**City of Albuquerque Stormwater Construction Site Inspection Report**

General Information					
ESC File No.	L09E042A	Project Name:	Mercado El Milagro Bldg. D & Bldg. G		
NPDES Id. No.	NMR10056E/NMR1005MD	Location:	10000 Central Ave SW		
9/19, 9/24/2024	Owner	Contractor			
Operator	PPI II, LLC	Wilger Enterprises			
Contact name & title	Doug Peterson	John Wilger			
e-mail	<a href="mailto:doug@petersonproperties.net">doug@petersonproperties.net</a>	<a href="mailto:jwilger@wilger.com">jwilger@wilger.com</a>			
Contact Phone #	505-884-3578	505-345-2854			
<b>COA Inspector</b>	<b>Chancellor English</b>	Start/End Time:	1PM		
Construction Phase:	Building D complete but no power, Building G graded and inactive				
Type of Inspection:	<b>Regular</b>	Storm Event	Post Storm Event >0.25"	311/Complaint	Follow Up
Weather at time of inspection?	Clear		Temperature: ~	85	
Estimated date of last storm 0.25" or greater	8/31/2024

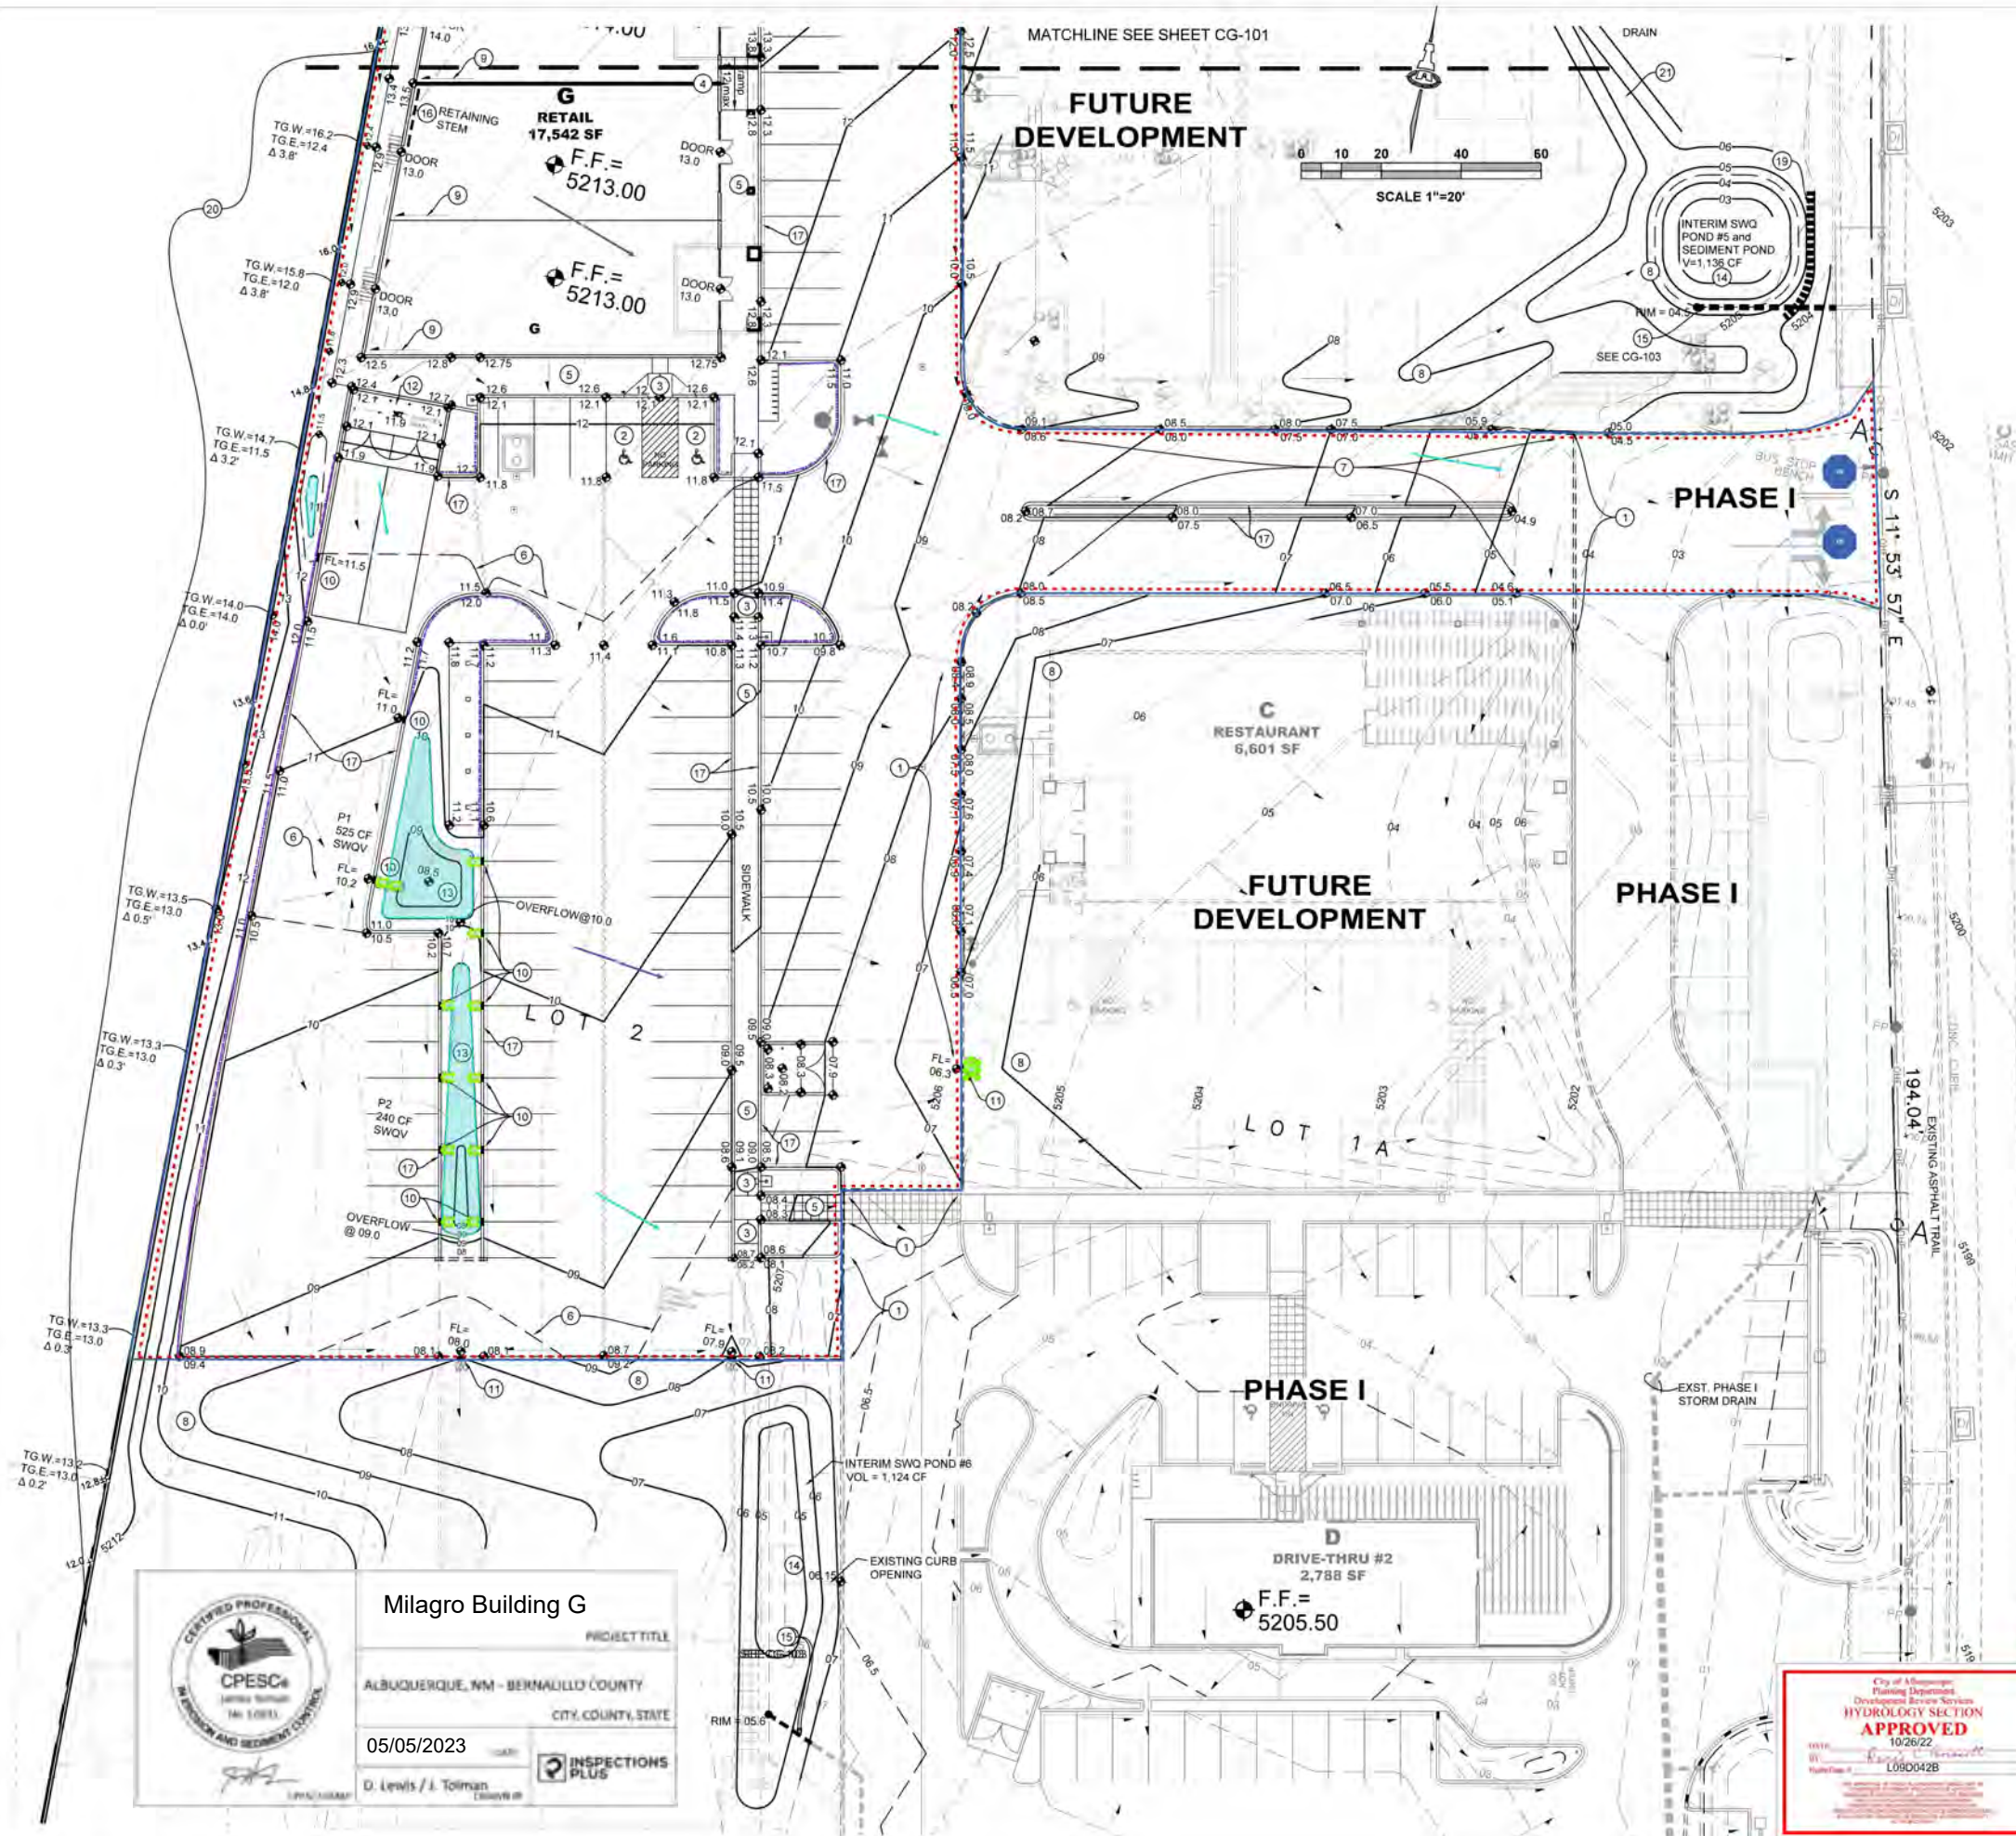
3	Stabilization - The land disturbances for both Building D and Building G have been inactive for several months without any stabilization measures installed in violation of CGP Part 2.2.12. Required mitigation: Initiate the installation of stabilization measures immediately in any areas of exposed soil where construction activities have permanently ceased or will be temporarily inactive for 14 or more calendar days and complete the installation of stabilization measures as soon as practicable, but no later than 14 calendar days per CGP Part 2.2.14.
